Re: The Artist's Studio **CC:** Archtype

Notes: The following are items that need to be addressed as a result of an initial plan review plan review for Building Code Compliance:

A1

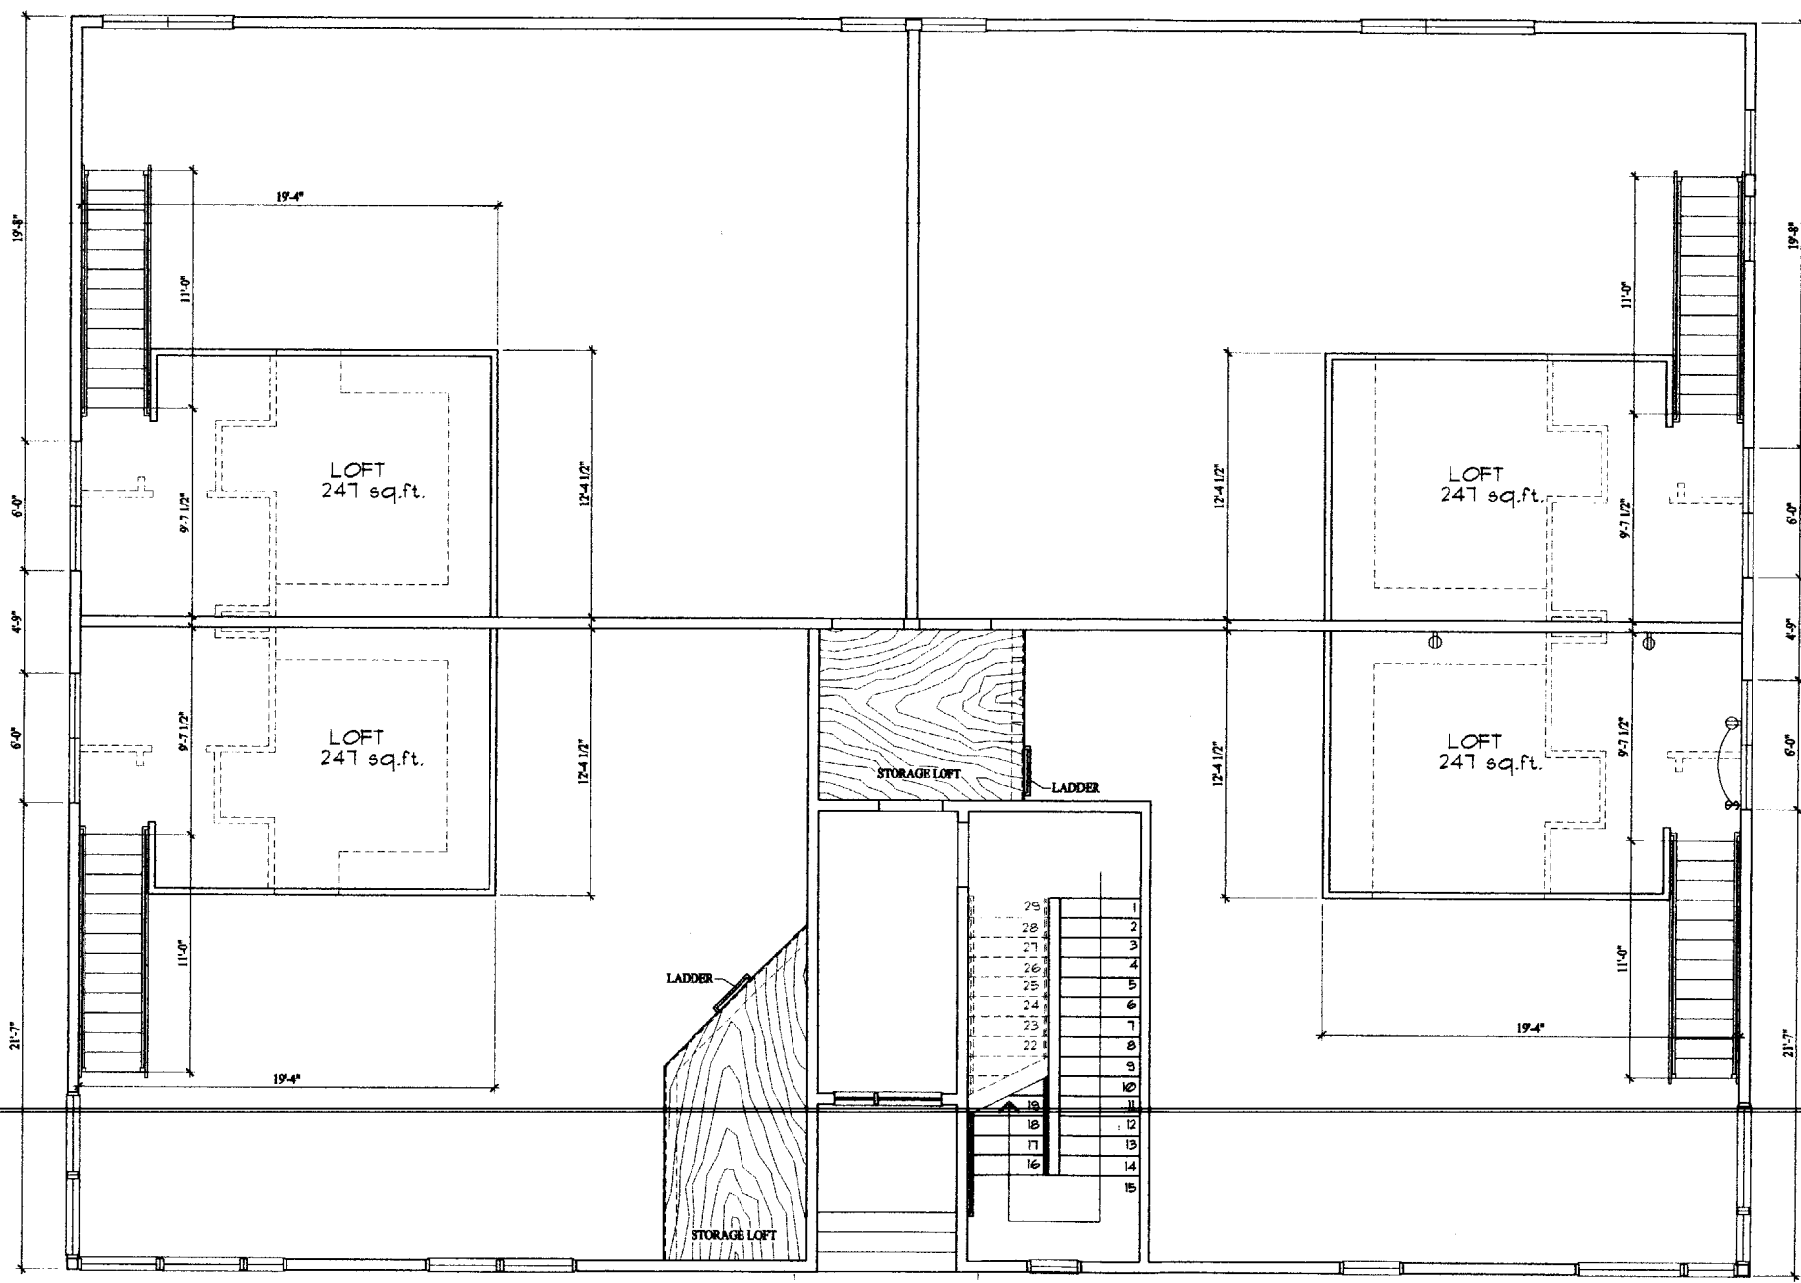
- 
- 1) **Fire Rating of floor/ceiling & roof assemblies**
 - 2) **Dwelling unit fire separation and sound transmission rating**
 - 3) **Section 705.6 required a parapet wall on the south wall**
 - 4) **There is 17% glass/glazing on the south wall / 15% is the maximum (705.3 and 705.6)**
 - 5) **Roof load for rain and snow must be designed in accordance with Section 7 & 8 of ASCE 7-95**
 - 6) **HVAC Plans**
 - 7) **Guardrail details for mezzanines and interior egress stairways**
 - 8) **Spiral Stair Details**
 - 9) **Statement of Special Inspection as required by Section 1705.1.1**
 - 10) **Ladder access to storage areas is prohibited**
 - 11) **The storage areas do not have guards**
-
-
